STATE OF NORTH CAROLINA
DEPARTMENT OF TRANSPORTATION

March 15, 2019

Subject: Revised Application for Section 404 Individual Permit and Section 401 Water Quality Certification for US 158 improvements from I-95/NC 46 in Roanoke Rapids to SR 1312 (St. John Church Road) in Northampton County. TIP R-2582A. WBS 34472.1.4.

SITE 6

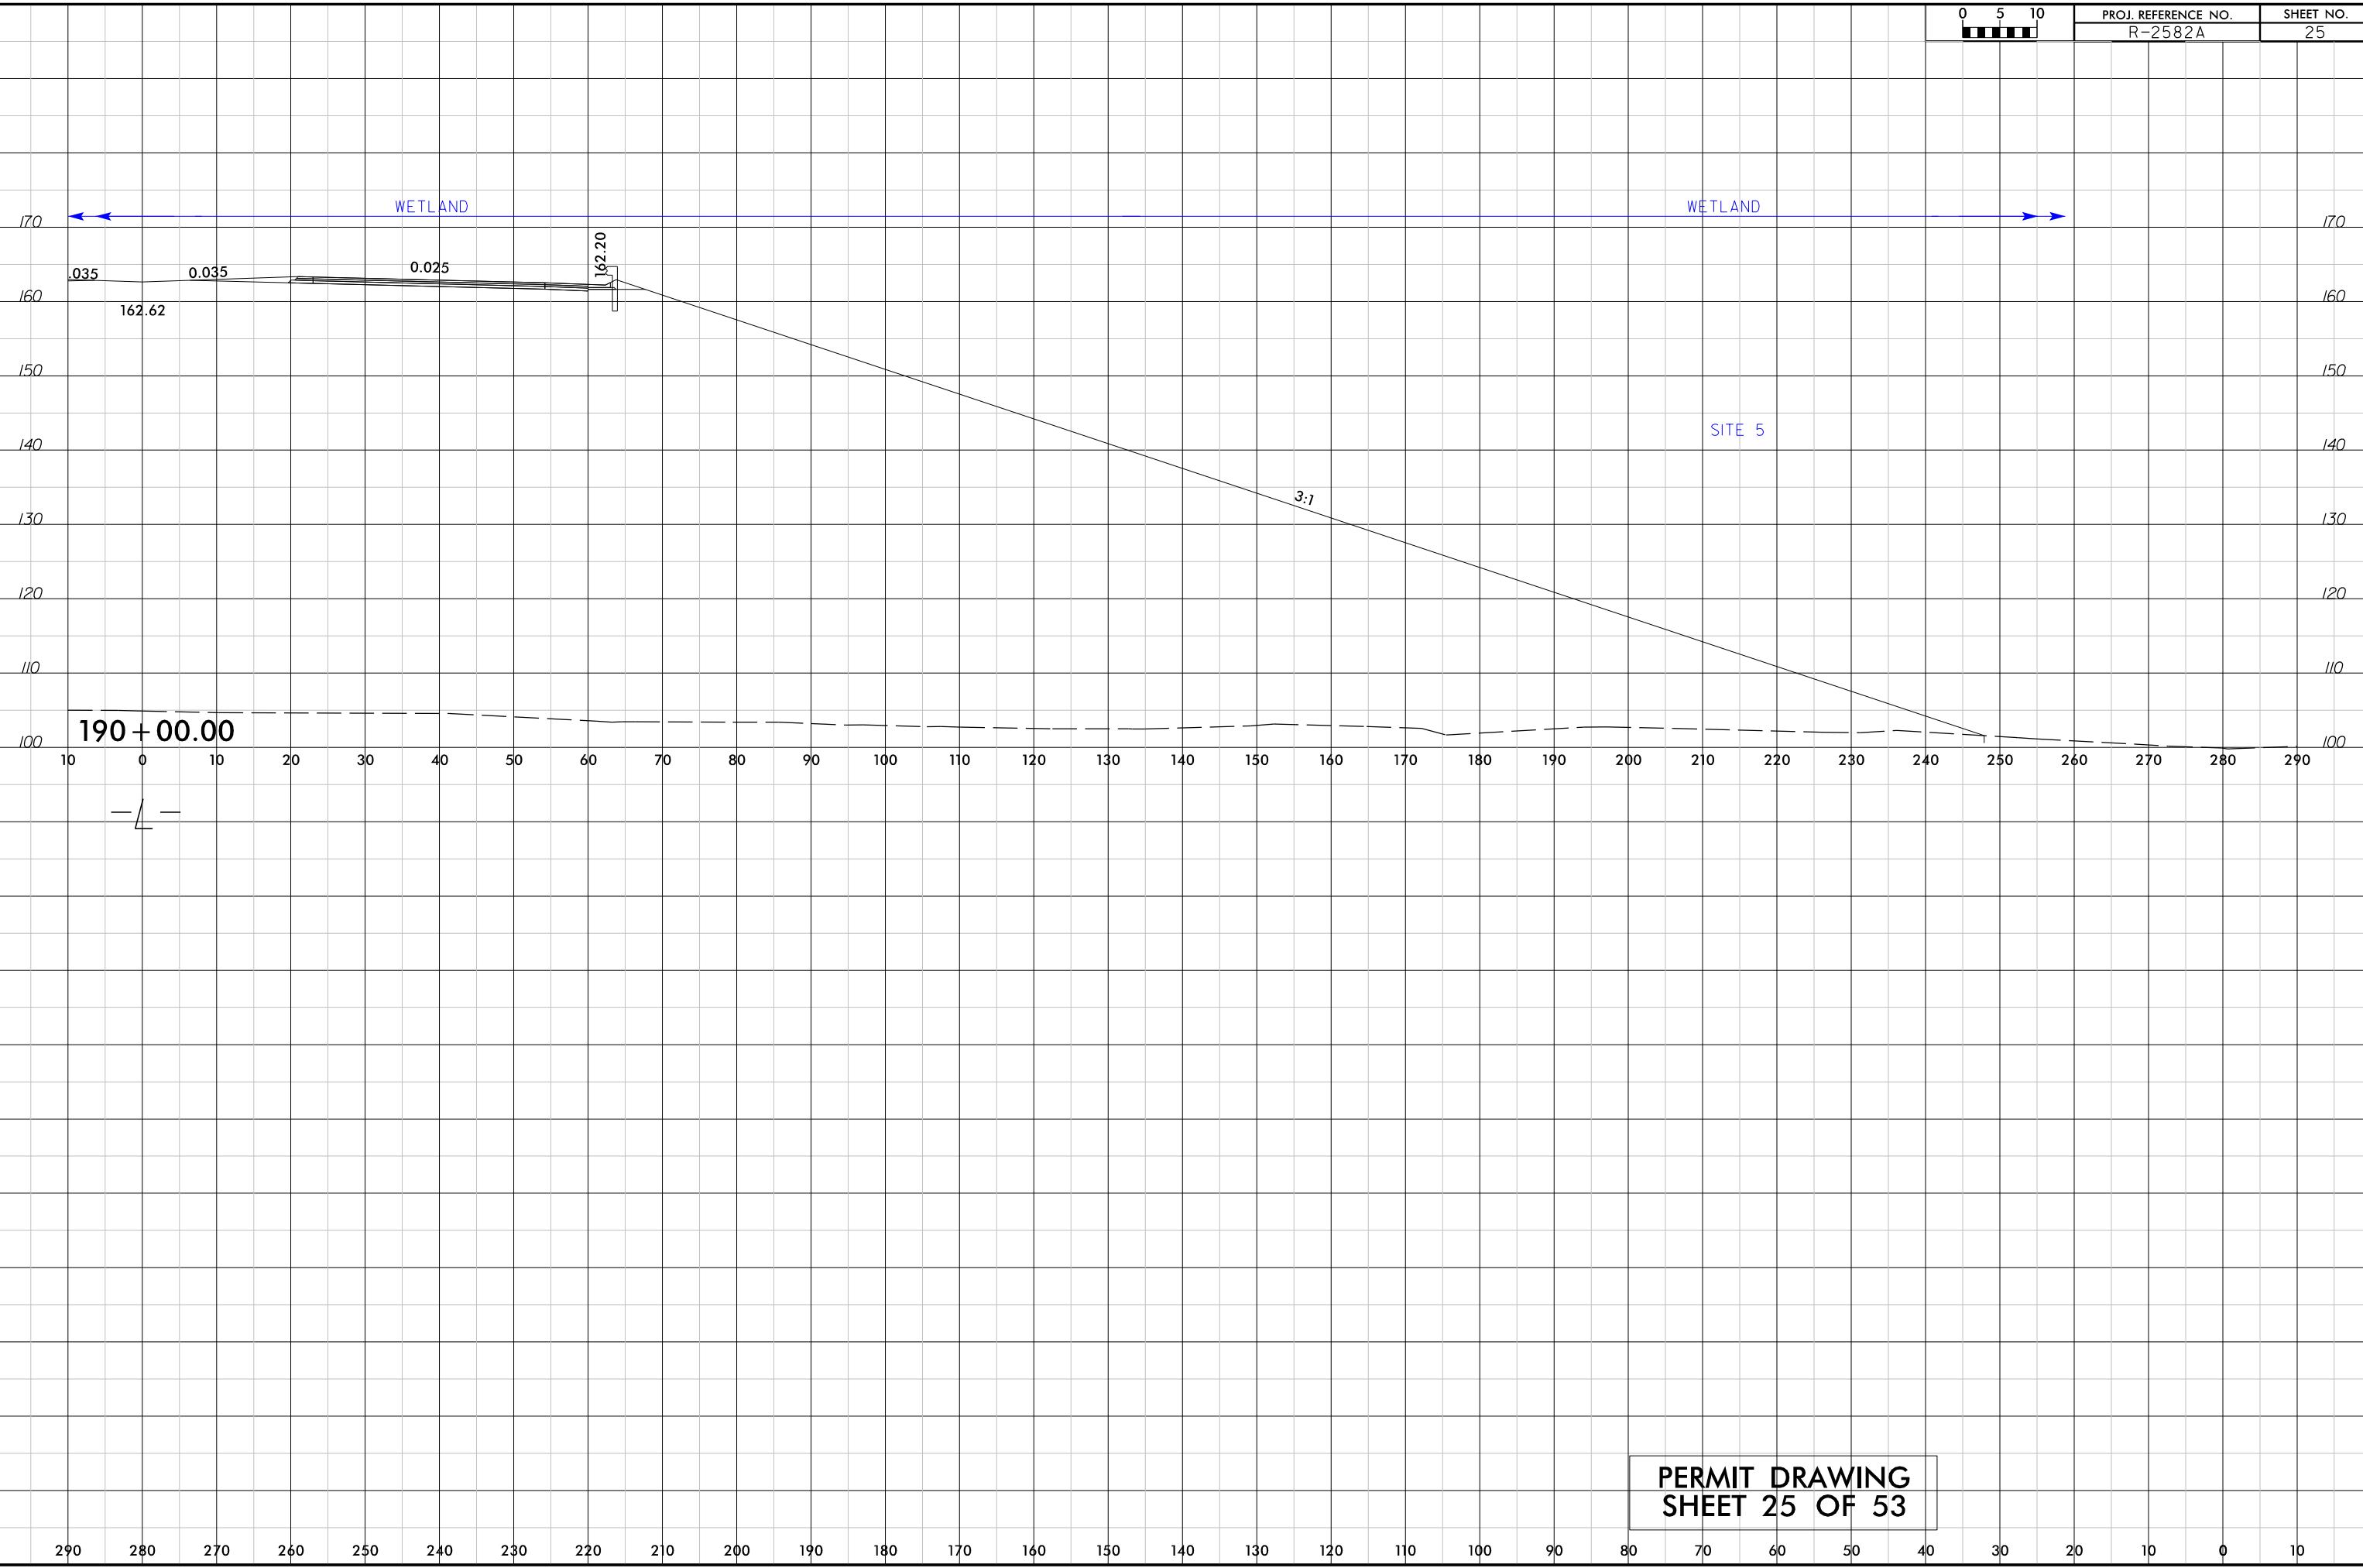
Wetland Site 6 includes a 0.465 acre wetland area inside the interchange loop that is not filled, excavated or cleared mechanically. However, the impacts to the total site are such that this area will likely also cease to function as a wetland and therefore considered as a total take. Table 2 (from p. 3 of the application) is revised to include this area under Permanent Impacts.

² Site 6 includes 0.465 acre of impact inside the interchange loop.

Site 6 includes 0.465 acres of fill impact due to the total take of wetland within the proposed roadway loop.
